8th March 2022

Application No: AB/10/22/HH
Site Address: 75 Maltravers Street Arundel BN18 9BQ
Description of works: Single storey side extensions.
(This application may affect the setting of a Listed Building. This application affects the character and appearance of the Arundel Conservation Area).

Thank you for your internet representation made on 7th March 2022 which has been recorded as an objection with the comments as follows:

TITLE
Proposed
Floor Plans &
Elevations

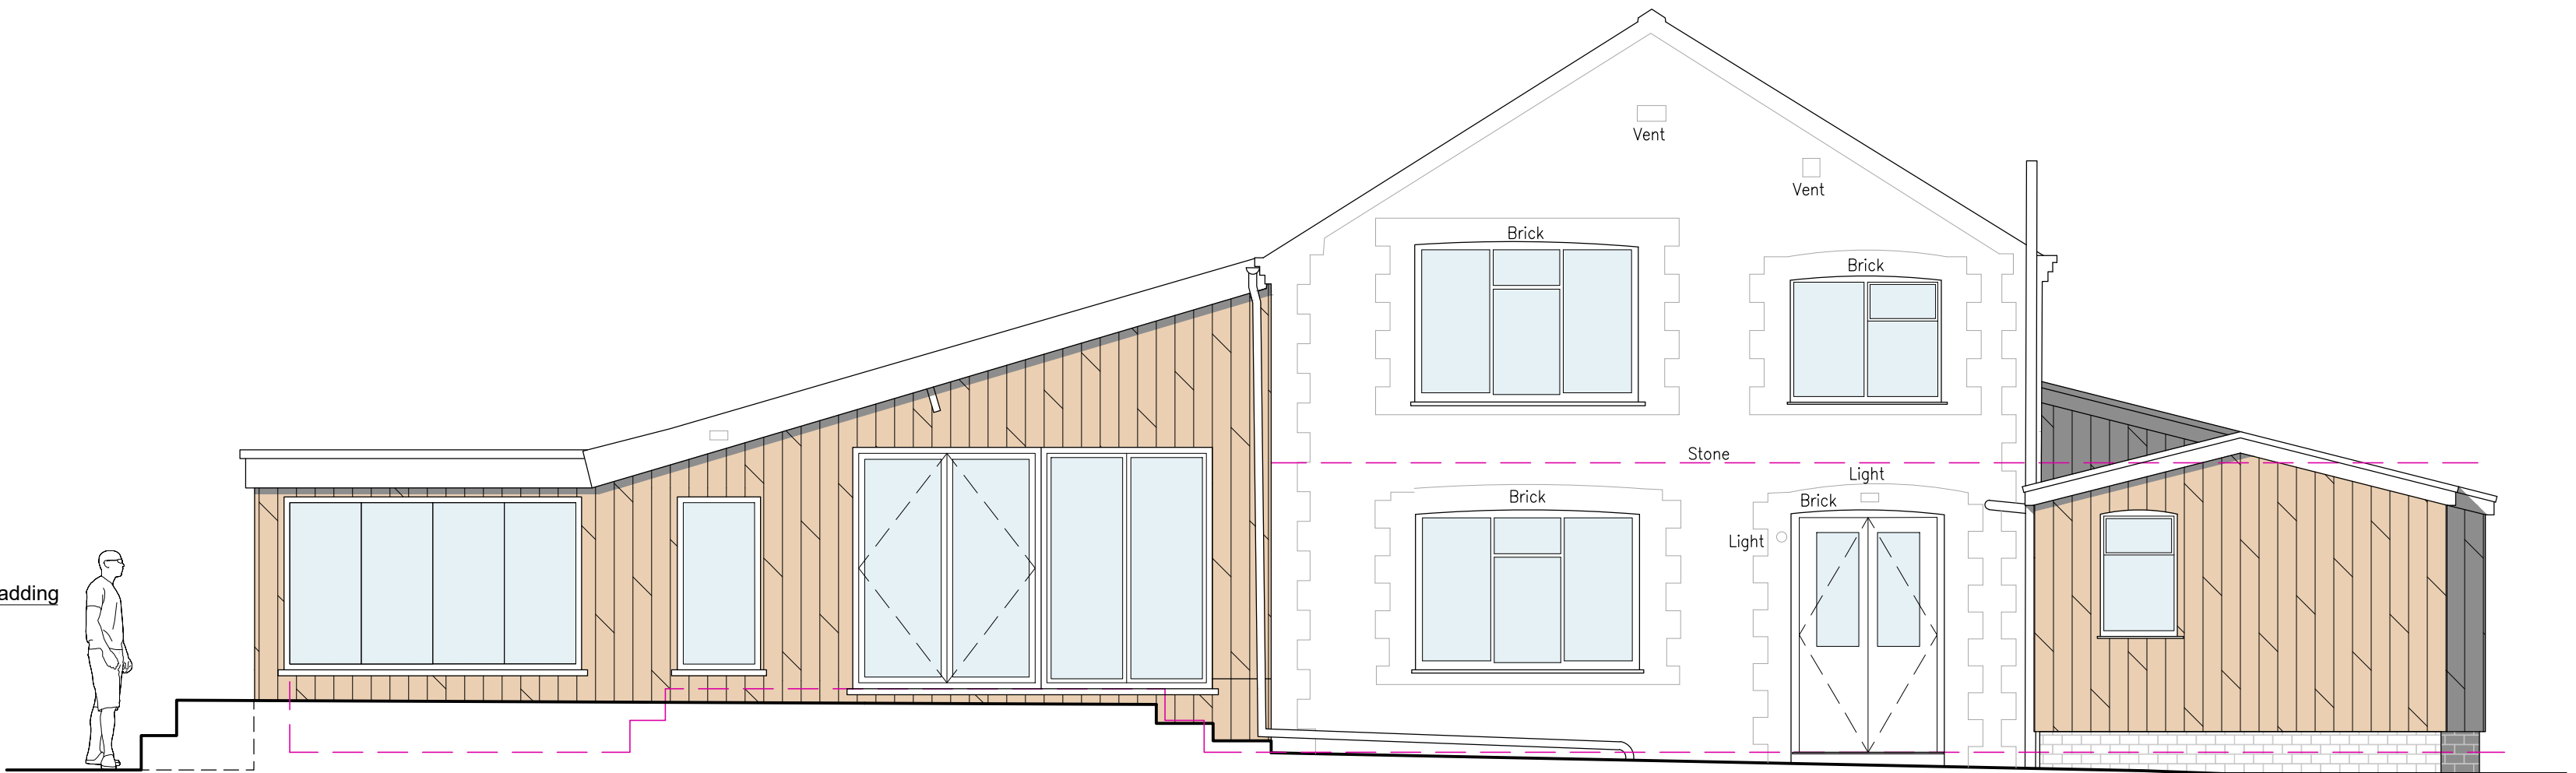
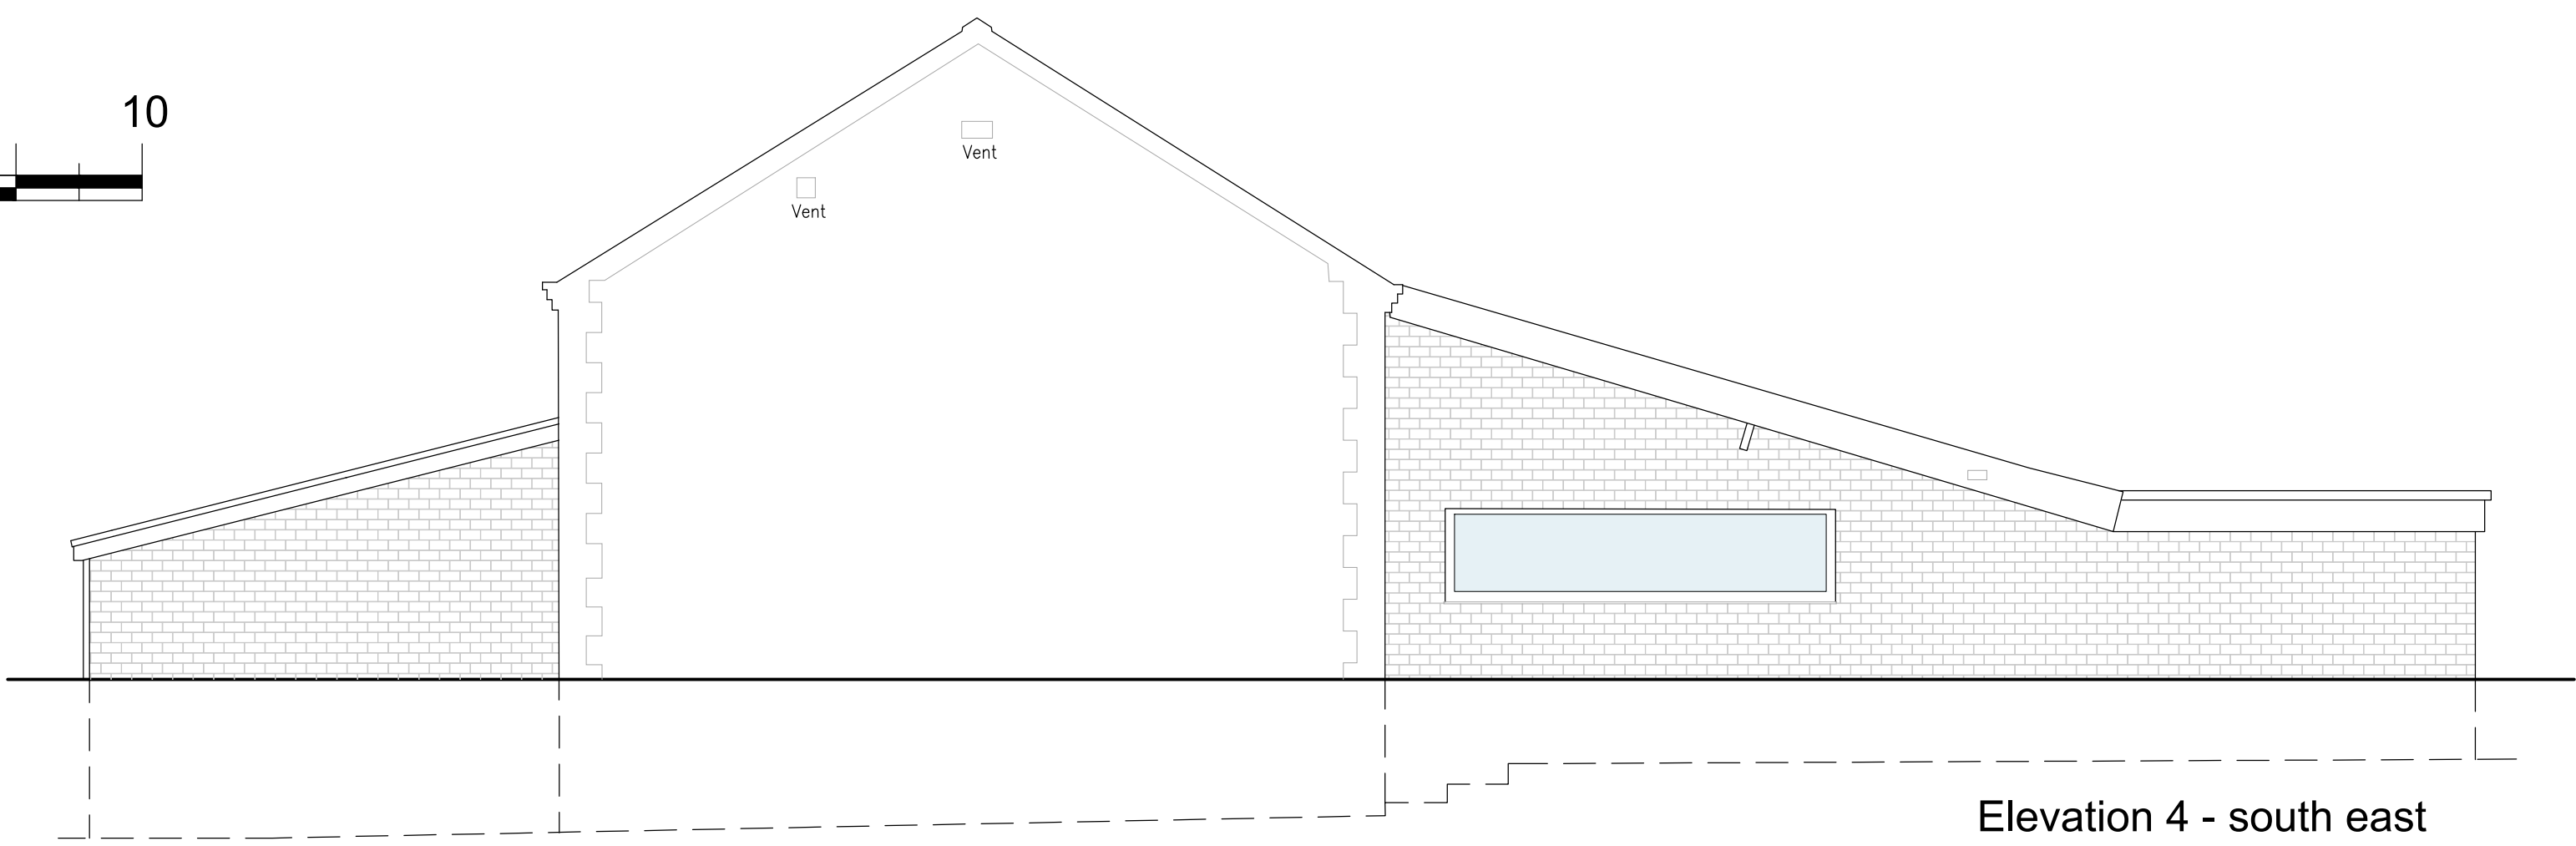
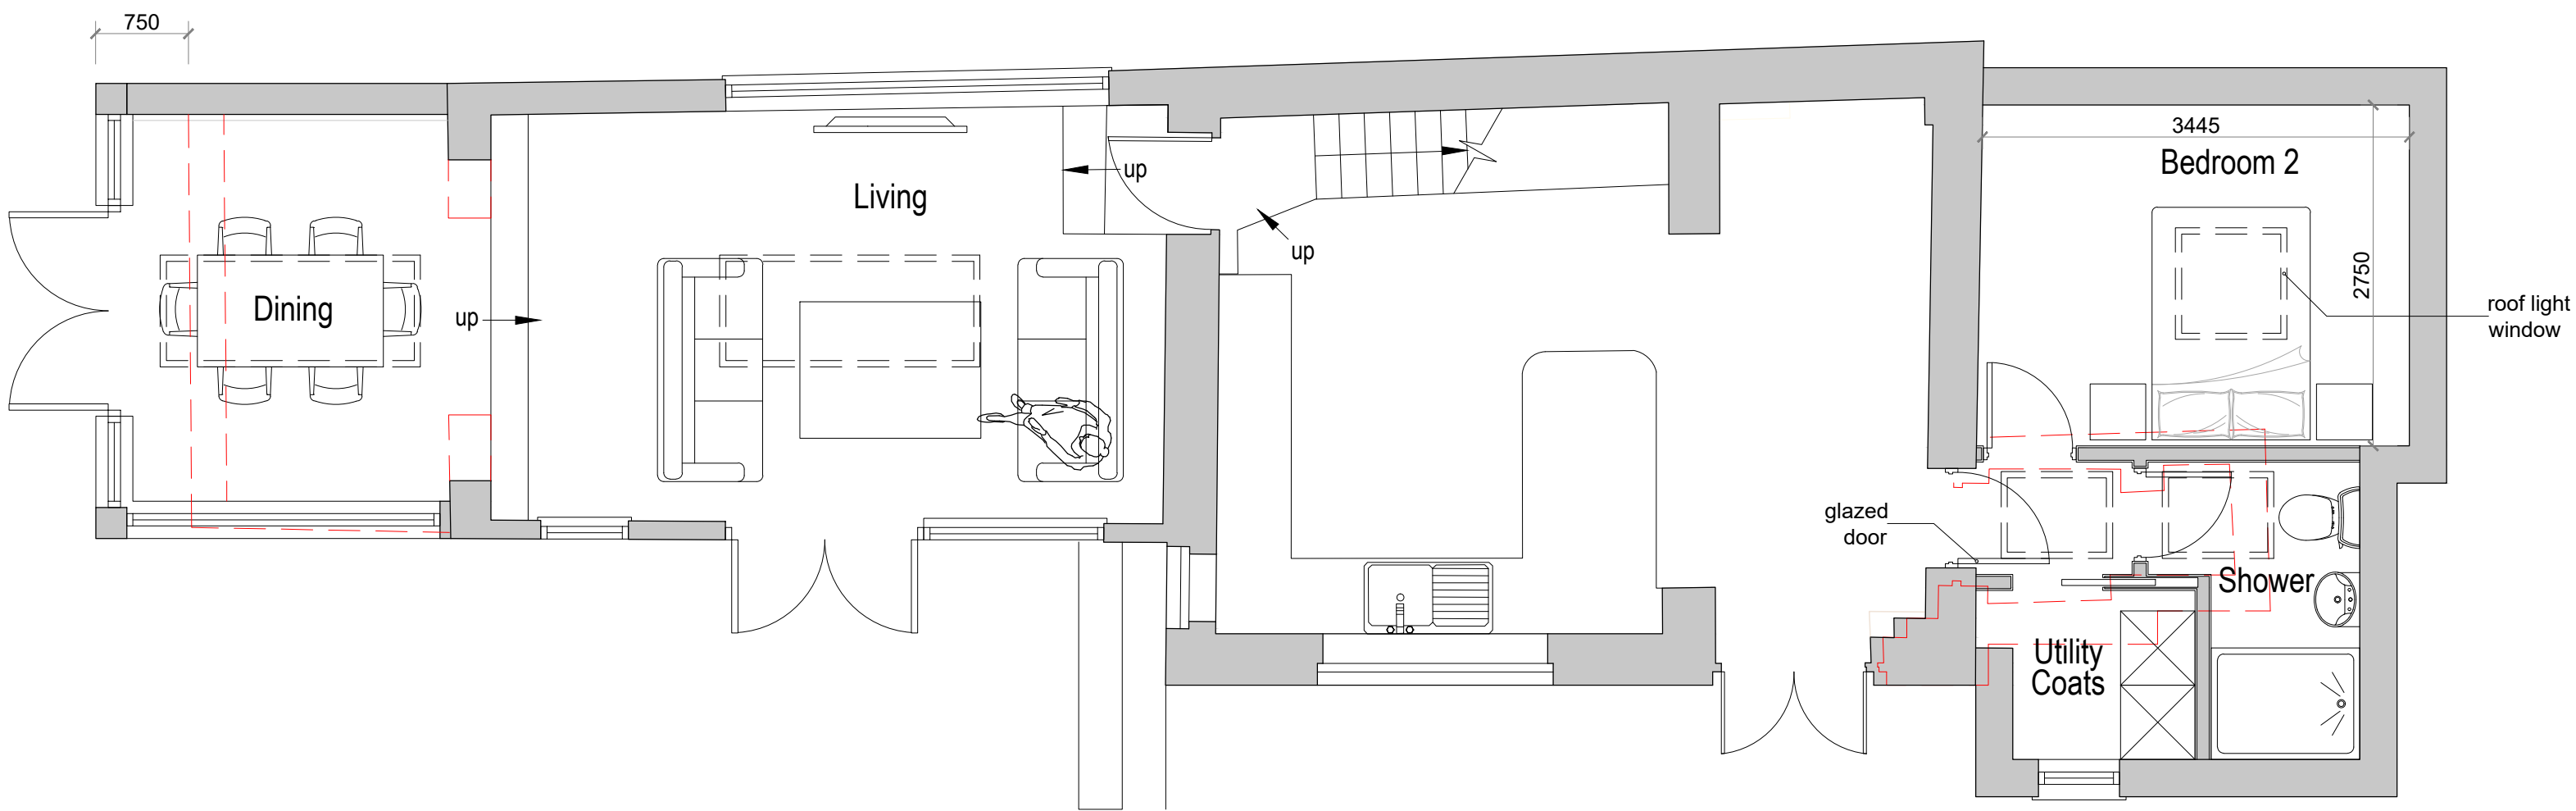
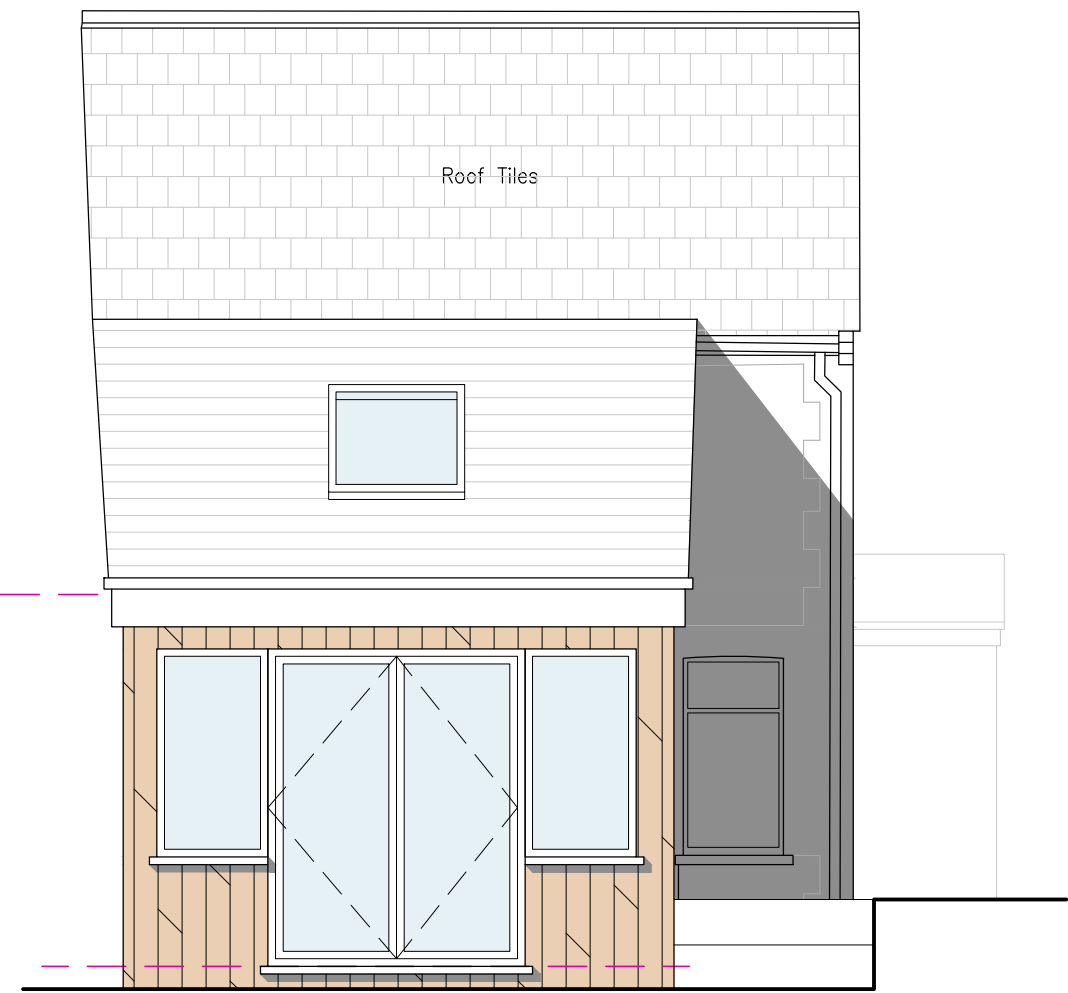
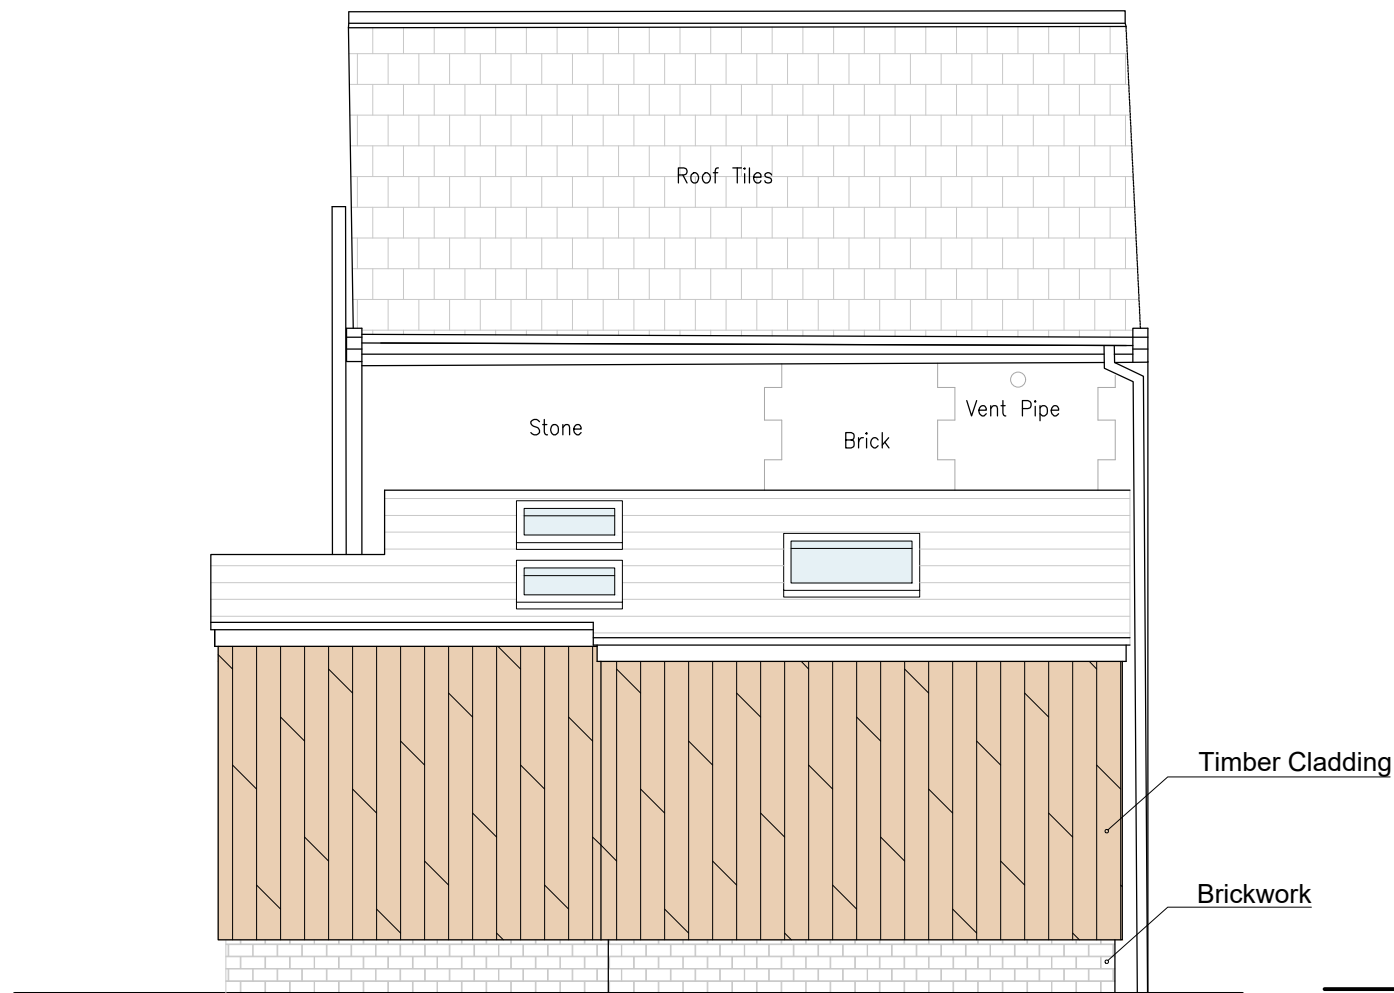
The Committee objected to the Application based on the use of the material choices of PVC double glazed windows, not achieving a visual quality in accordance with policies HER DM3 and D DM1 of the Arun Local Plan.
